RE: Abbitt Residence  
575 Highgrove Dr, Spring Lake, NC 28390  
Client Project #: 575ABBI  
PFE Project #: 184084

On behalf of PowerHome Solar, Penn Fusion Engineering LLC (PFE) performed a structural analysis of the roof design at the above referenced location. The purpose of our analysis was to determine if the existing design of the roof system is structurally sufficient to support the new photovoltaic modules in addition to the code required design loads. Our analysis is based on the information provided by PowerHome Solar and is isolated only to the areas where the modules are intended to be placed.

SHEET NUMBER
PV-3

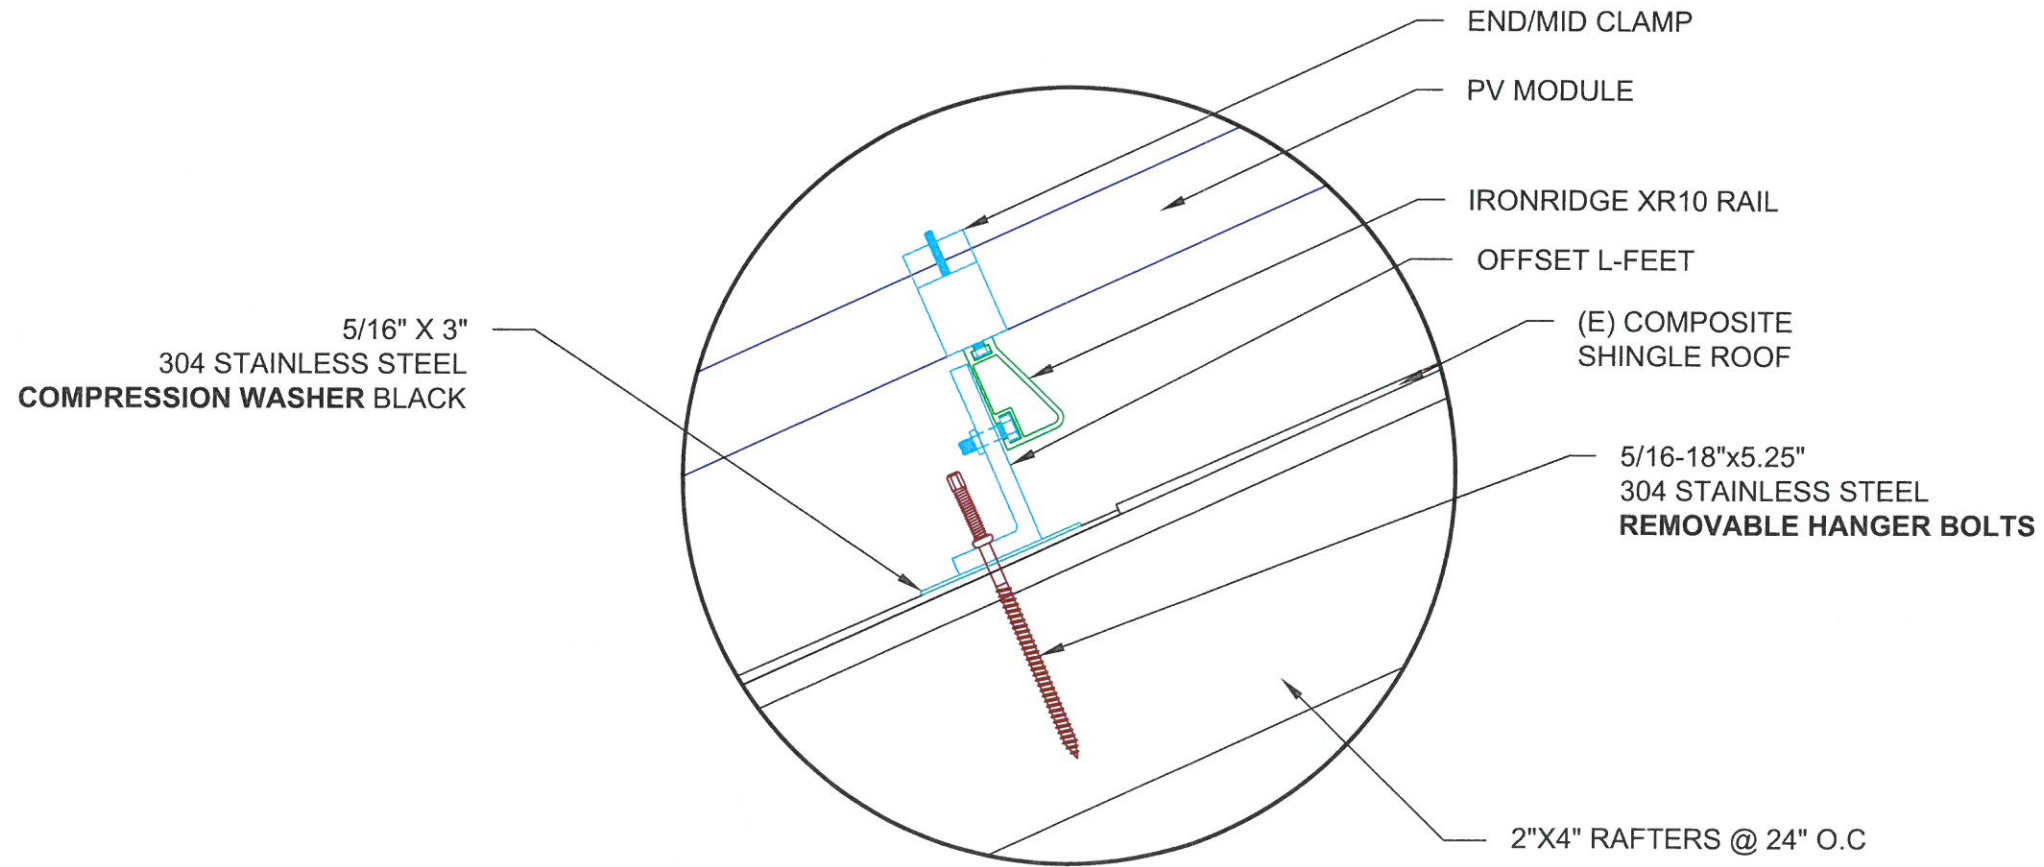
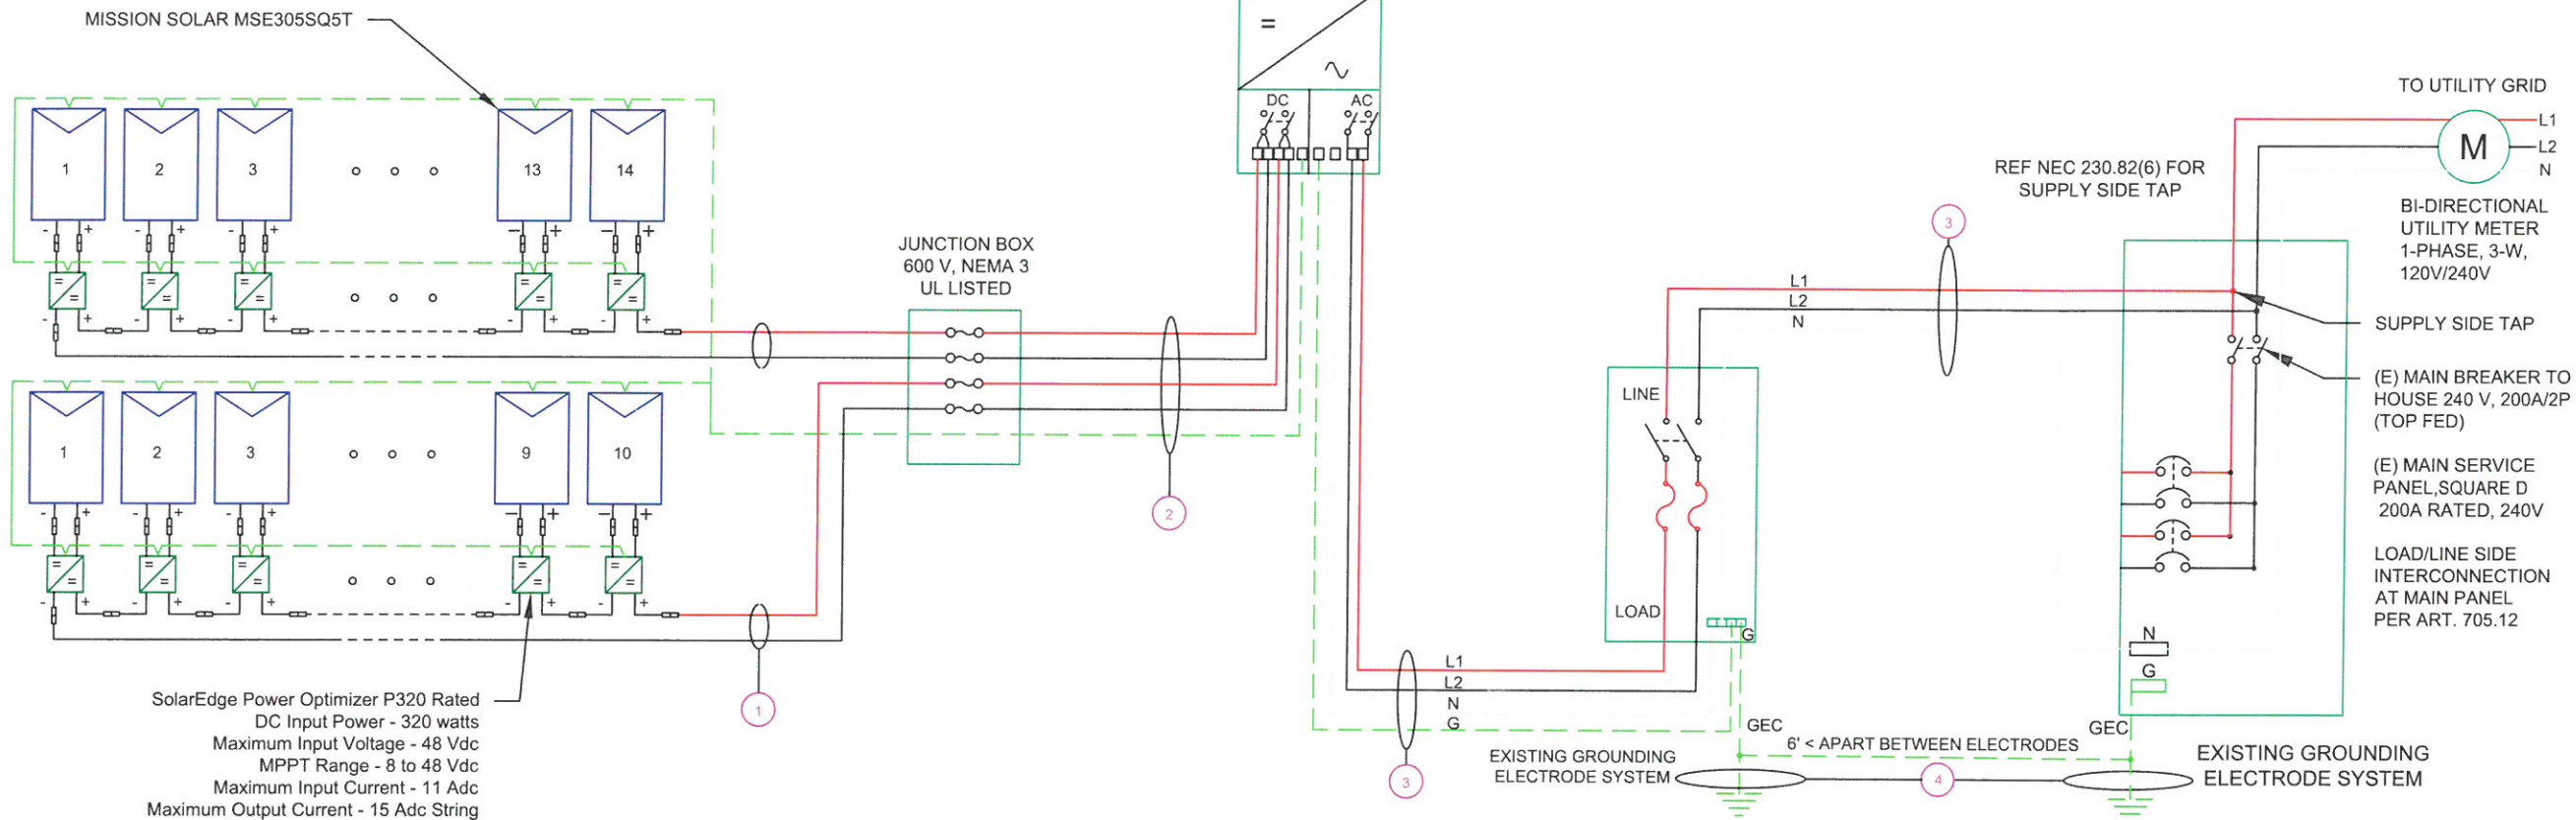
Mounting Plane 1  
The calculations for these structural members are attached. It has been determined by this office that the rafters, as specified above, exceed the allowable span for the total design loading. Attached are repair details that, when installed, will render the roof design structurally adequate to support the new PV modules in addition to the code required design loading.

Attach the module rail brackets to the roof with 5/16" lag bolts at 48 on center maximum. Provide a minimum of 2" of penetration into the wood members.

Install 5/16" diameter lag screws @ 48 on center with minimum penetration of 2" into rafter.

New Sistered Rafter Size: 2x6x6' Doug-Fir Larch #2 or better  
Nailing Requirements: (2) 10d Nails @ 12" on center with (3) additional 10d Nails at each end

Note: Apply repair to each rafter under PV system
